From: Local Development
Sent: 01 May 2026 15:39
To: DC Admin
Subject: FW: Planning application 2025/93457

Sent: 01 May 2026 13:52
To: Local Development <Local.Development@kirklees.gov.uk>
Subject: Planning application 2025/93457

SOUTH ELEVATION

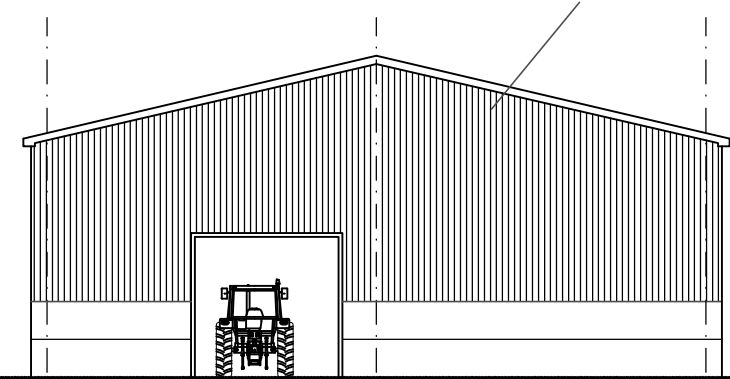
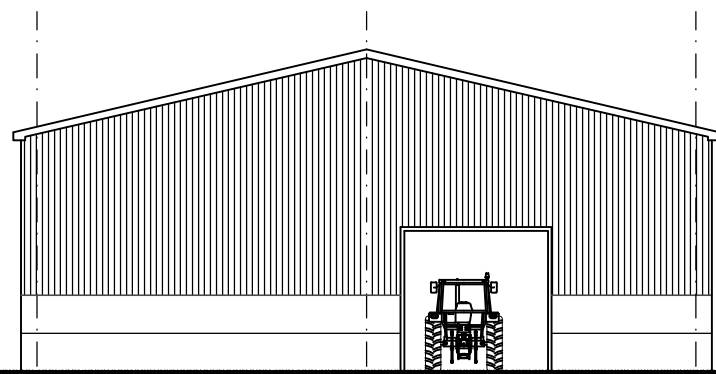
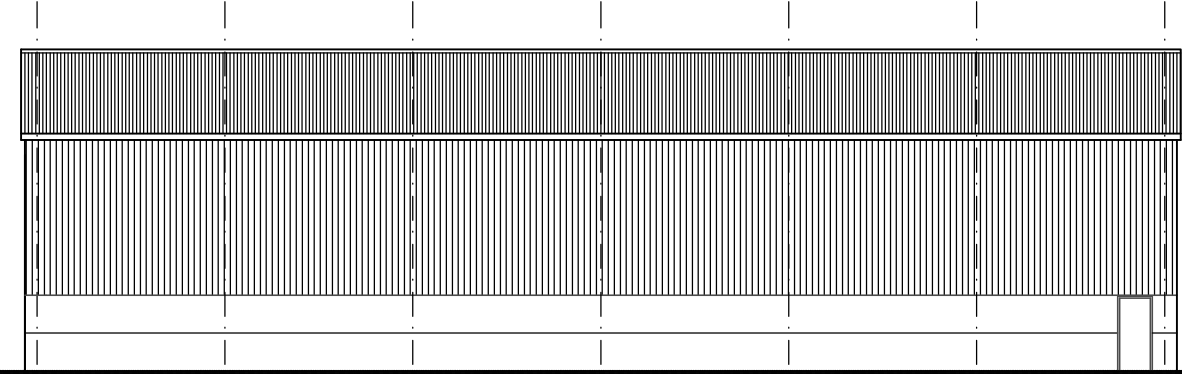
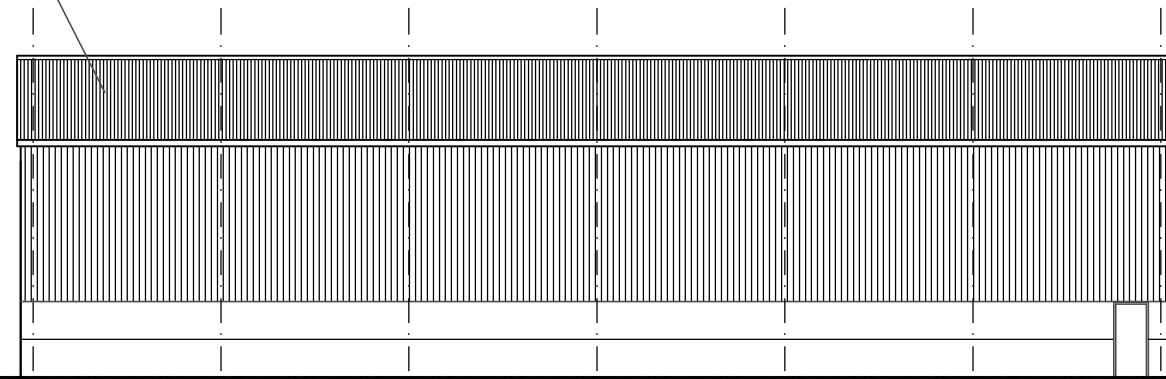
1 issue which does not seem to have been addressed is the excessive height of this building and the fact that in its current position on sloping ground the southern gable will far exceed the height shown on the plans .

If this development is going to be passed in its current location I feel very strongly that planners should consider digging into the land to reduce the impact to green belt . This is I believe a major policy of Kirklees's .

Reducing the height in any location would a major step in the right direction.
